From: John Ferguson [REDACTED]
Sent: 10 February 2026 16:18
To: Kathryn Welch <Kathryn.Welch@arun.gov.uk>
Subject: RE: BR/1/26/DOC

From: Kathryn Welch <Kathryn.Welch@arun.gov.uk>
Sent: 29 January 2026 15:39
To: John Ferguson [REDACTED]
Subject: BR/1/26/DOC

DRAWING TITLE
Flat 2 - Proposed Outdoor Amenity Spaces

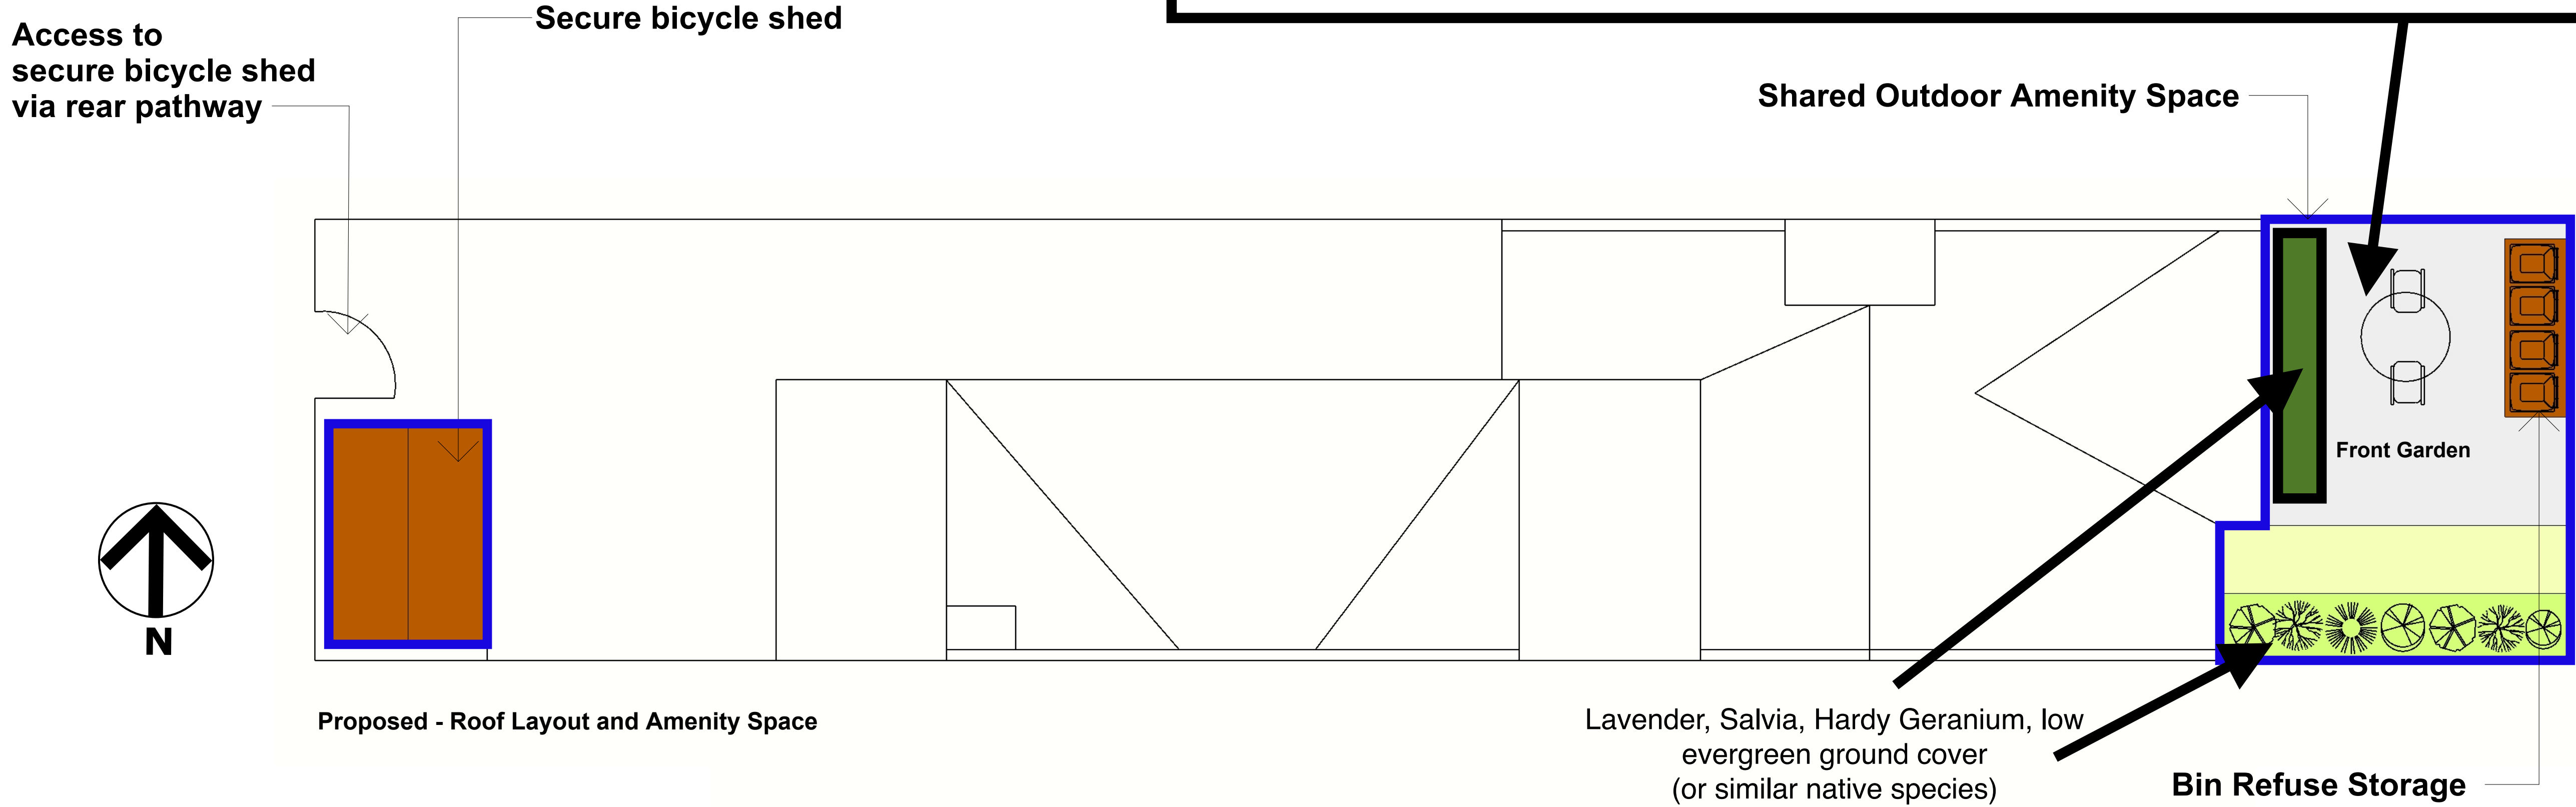
I would be grateful if you could provide further details in respect of the planting scheme. Could you provide an indication of how many plants will be planted, or how many plants per square metre of each variety will be utilised?

Further to your request, the proposed planting scheme will provide approximately 5–6 plants per square metre, in line with typical landscaping densities for low-maintenance amenity areas.

The planting area will include approximately 20–25 plants in total, comprising a mix of hardy, pollinator-friendly species such as lavender, salvia, and hardy geranium.

Indicative spacing will be around 35–45cm between plants to allow for healthy establishment and coverage.

The selected species are widely available, low-cost, and low-maintenance, ensuring the scheme is sustainable and can be maintained effectively over the required period.
